DECISION DELEGATED TO HEAD OF PLANNING

Application No: H16-0164-23 **Applicant:** Signal Infrastructure UK Limited

Proposal: Proposed 16.0m Phase 8 Monopole & associated ancillary works

Location: Holbeach Road Streetworks Holbeach Road Spalding

Title:
260 PROPOSED ELEVATION

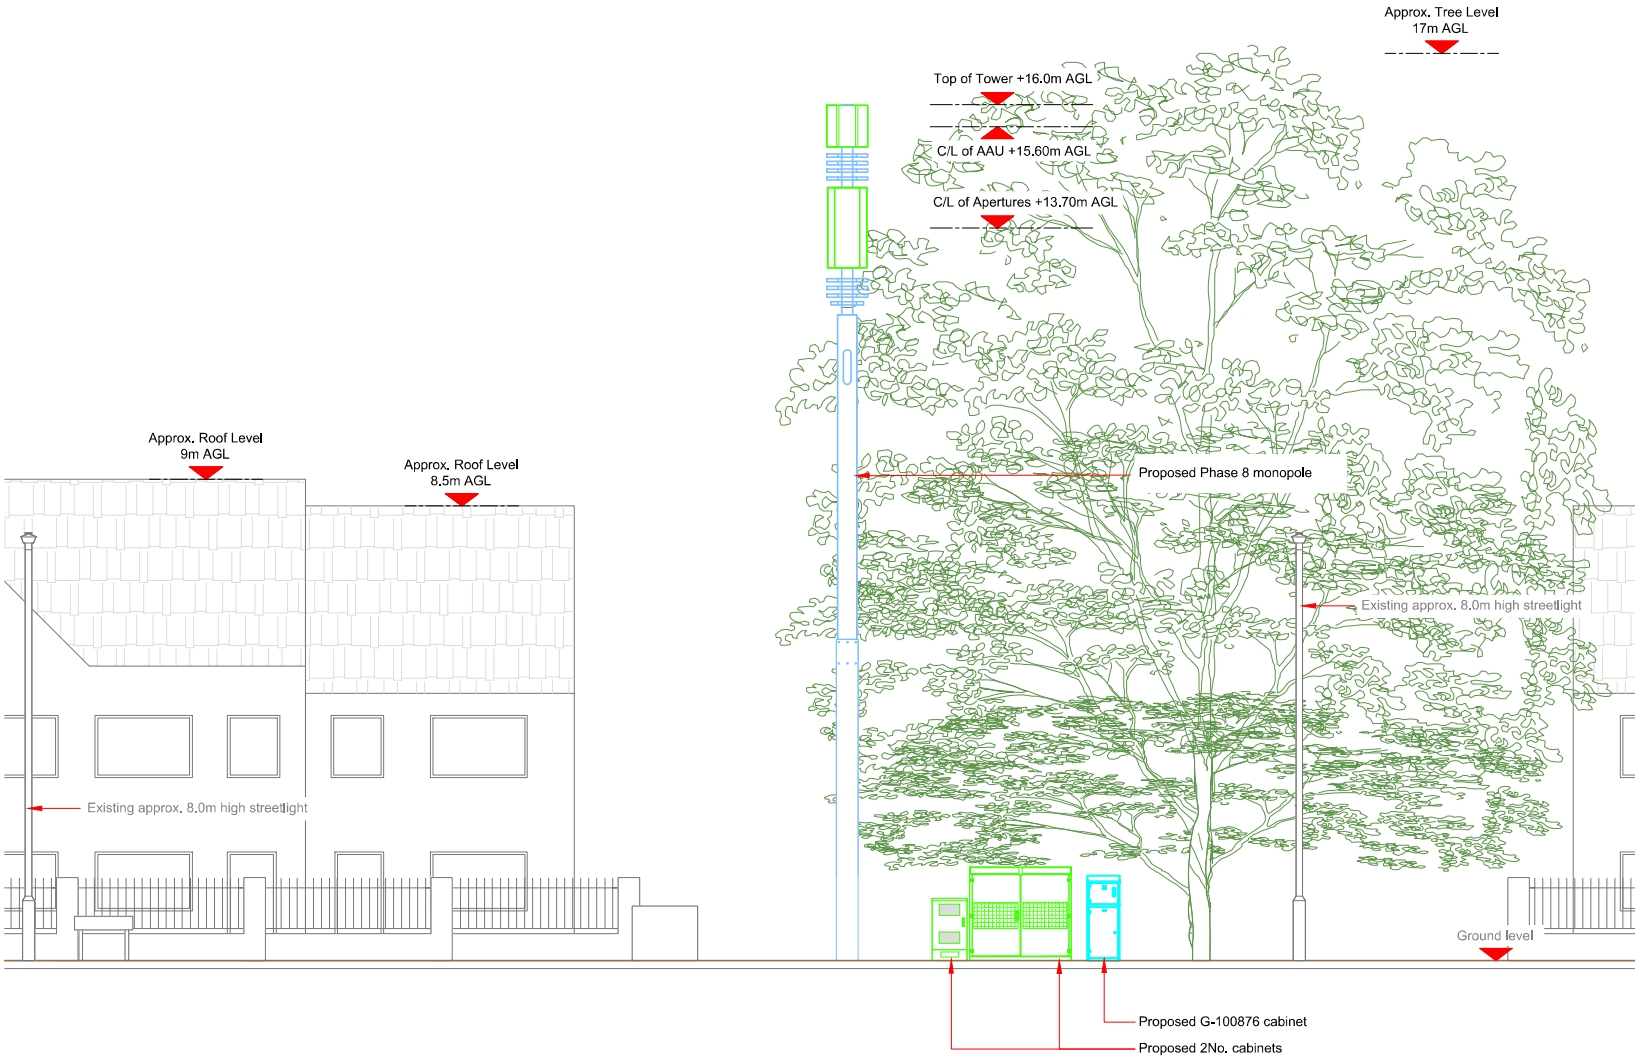
When there are so few trees in the District compared to some, why place this proposed development in such close proximity to one? It will aesthetically spoil the appearance of the balanced canopy of the tree, when viewed from the west/roadside.

As the tree grows there is very likely to conflict with its branches. (Presume the tree is the ash along Holbeach Road which greatly contributes to the street scene, but comments would apply to any significant tree.) Trees can lose branches in storms, which potentially could cause problems.

Will the proximity of the tree affect the purpose of the pole? We do not want to be in a position where the tree has to be trimmed as it is affecting signals.

In any case, may be it would be prudent to reverse the position of the proposed cabinets to nearer the existing one, to reduce potential future conflict with the tree.

How is the pole fixed in the ground? beware of potential excavation and tree roots.

The monopole would be readily visible in the street scene and the scale is not directly not comparable to any other structure or building in the vicinity. It would be visible at a distance on Holbeach Road and Roman Bank and would disrupt the tree canopy of the nearby tree. The mast would be sited almost immediately adjacent to a well-used footway and highway and would therefore be visually obtrusive to pedestrians, as well as motorists. Whilst it is accepted that there is other street furniture in the vicinity (such as street lights, road signs and other service boxes), it is considered that the proposal would have a material adverse impact on the wider street scene due to it being an unduly dominant, obtrusive and alien feature within the street scene.

Should development go ahead the tree will require protecting to British Standard 5837:2012 directly prior to and during construction works.
